CITY OF ALBUQUERQUE

August 2, 2018

RE: **Nuevo Atrisco
Central and Unser NW
Conceptual Grading and Drainage Plan
Plan Date: 7/26/18
Hydrology File: K10D058**

CG-101

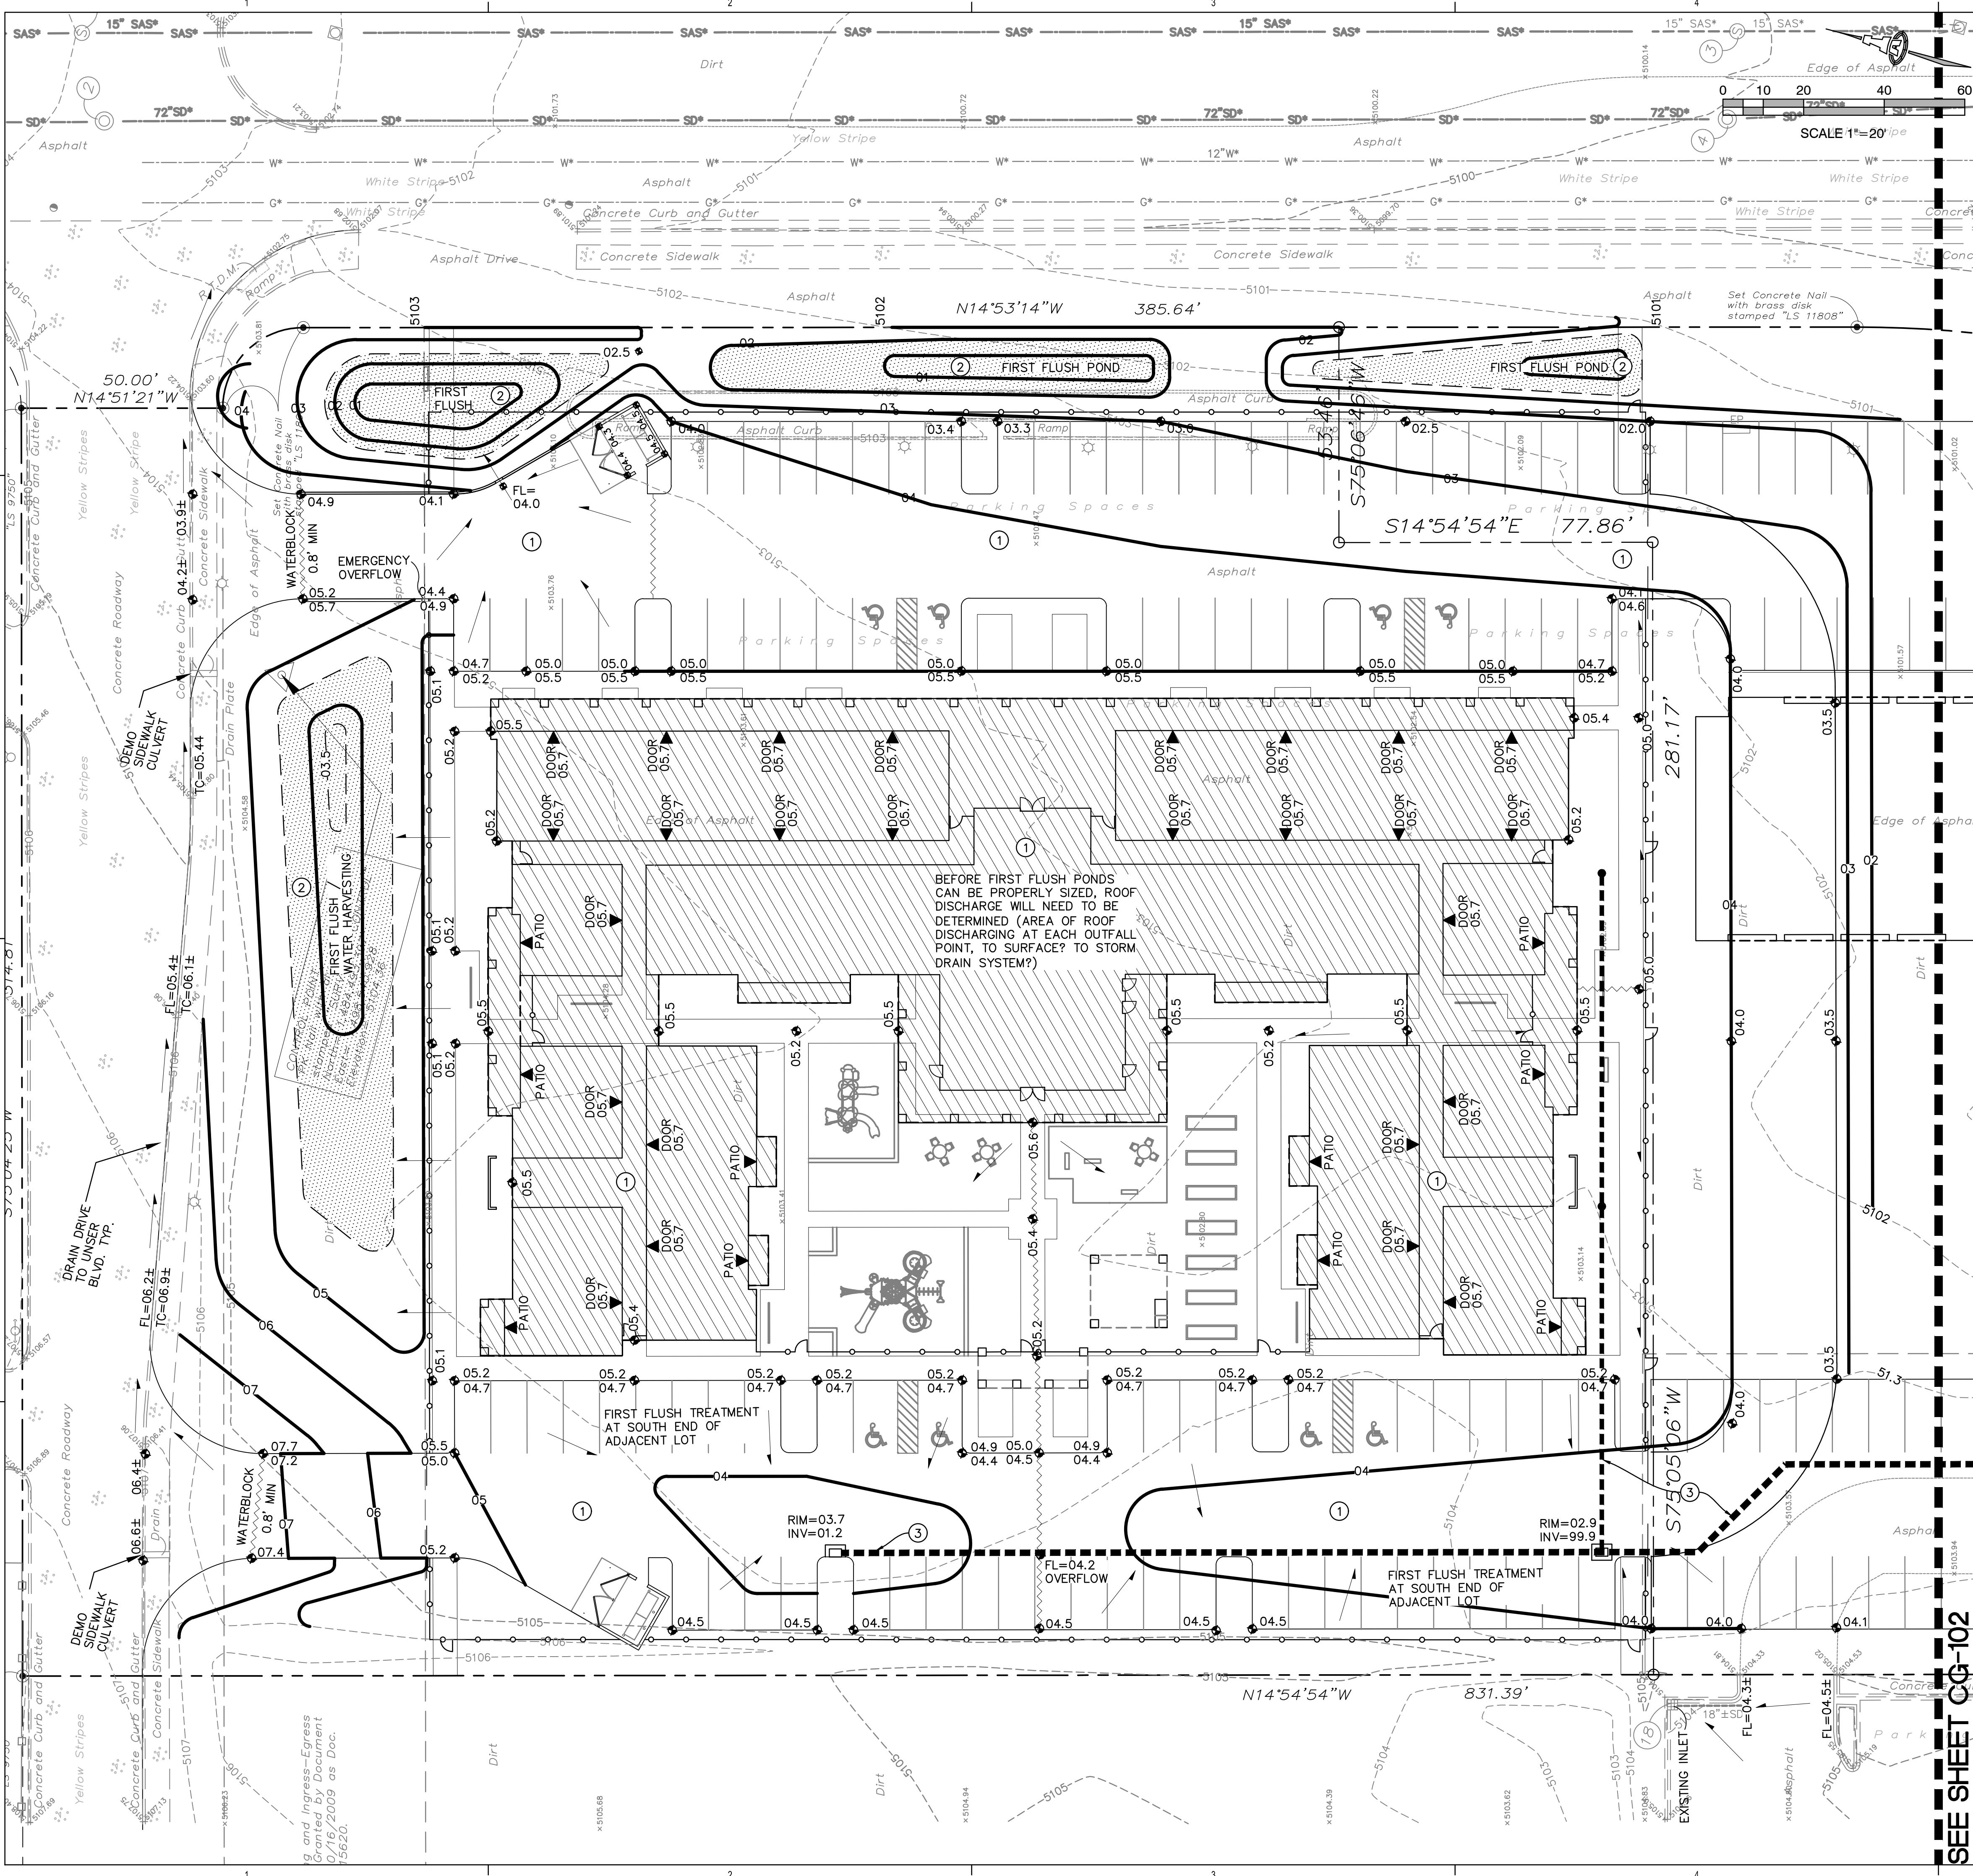
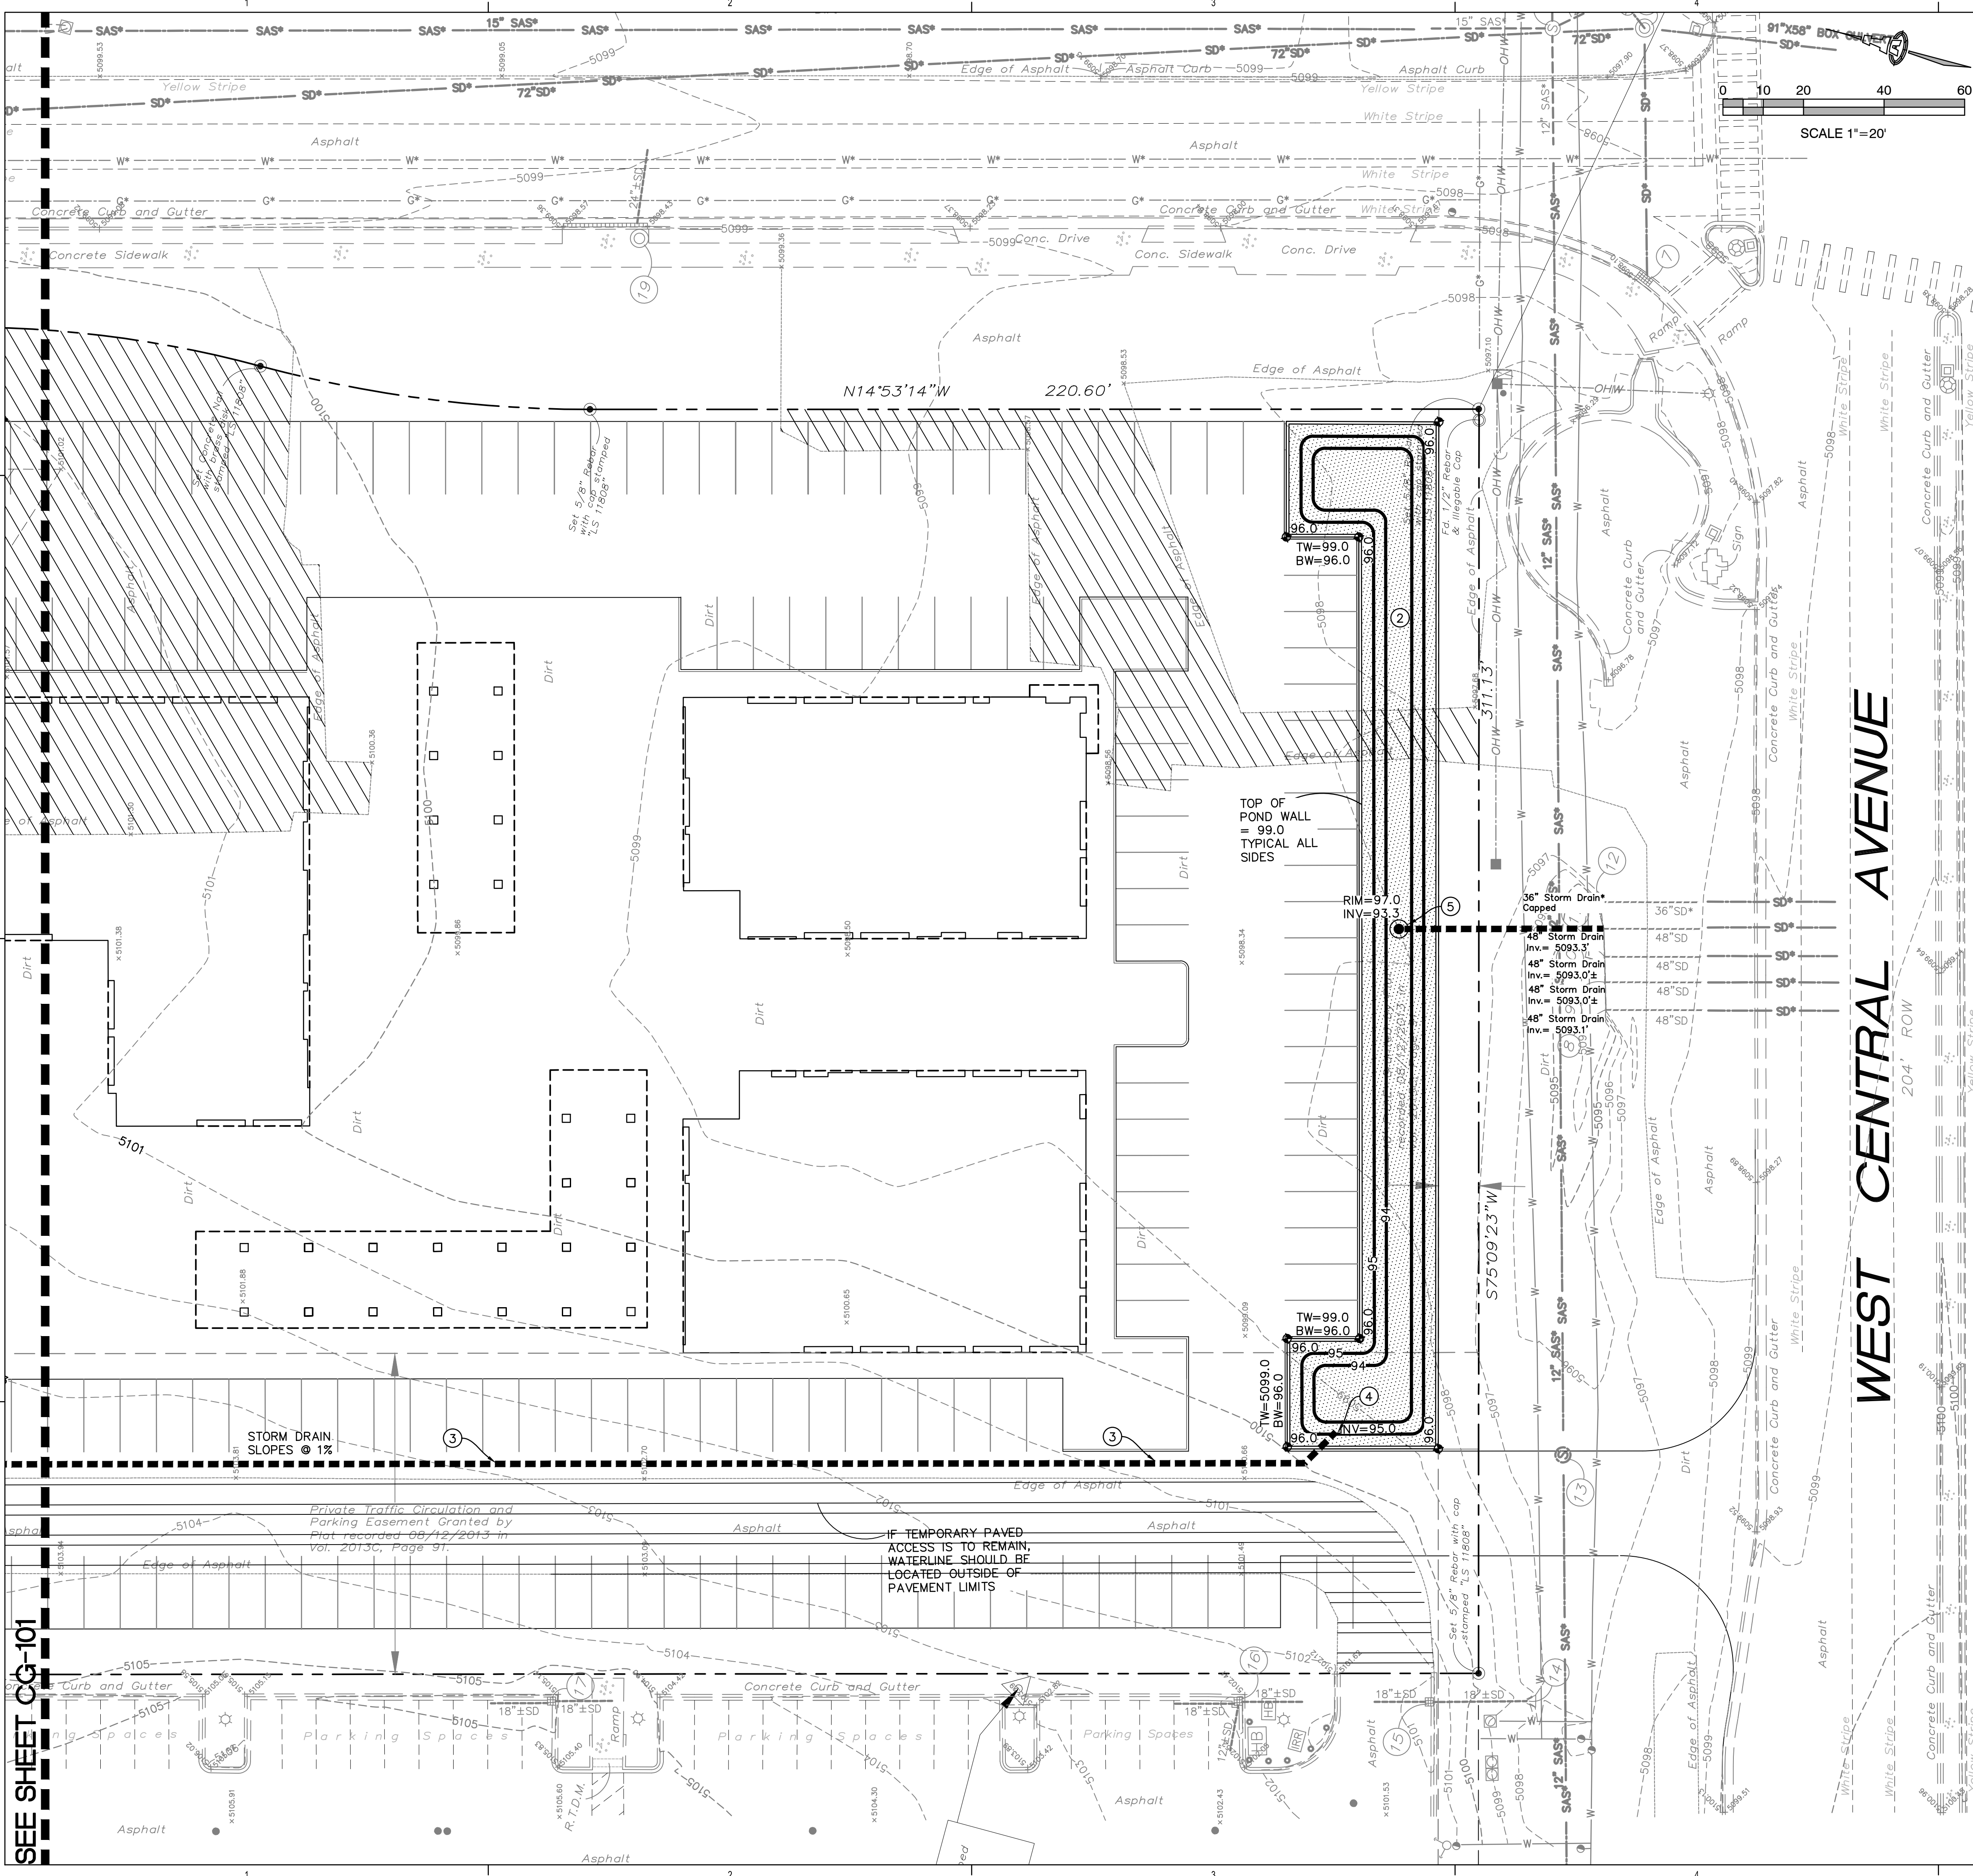
1. The Tract A Basin needs to be further divided. Only the east portion of the Tract A will actually drain to the proposed pond; the west portion will free discharge to the private storm drain. The detention pond and orifice plate needs to be designed with the assumption that only part of Tract A will drain to it. i.e. Q_{in} will probably be closer to ~6.5cfs so Q_{out} will need to be limited to ~1-2cfs to meet the allowable discharge requirement for the larger site.

2. The Drainage Report will need to be stamped and signed by the Engineer; calculations will need to be re-verified with respect to the final site layout, especially the 80% impervious assumption and the assumed subbasin divides for Tract A.
3. If Tract A develops first, its downstream conveyance (private storm drain) across Tract B to the connection on Central will need to be constructed with Tract A and certified prior to C.O.
4. Remove all "Conceptual" markings.
5. Proposed contours and spot elevations are missing from sheet CG-102.
6. The waterblocks along the north drive aisle need to be 0.87' min. (not 0.8') unless supporting calculations for a variance can be provided.

7. For trash enclosures serving food service developments (if any are proposed for this site), demonstrate control of liquids from dumpster areas per DPM Chapter 22.9.E, Table 1 by containing runoff from the dumpster area and discharging to the sanitary sewer. If this information is on the utility plan please provide it, or show on the grading plan.

8. Subbasins will need to be delineated for each first flush pond and each pond sized for the area draining to it. Roof runoff needs to be routed to the ponds once the site layout is finalized.
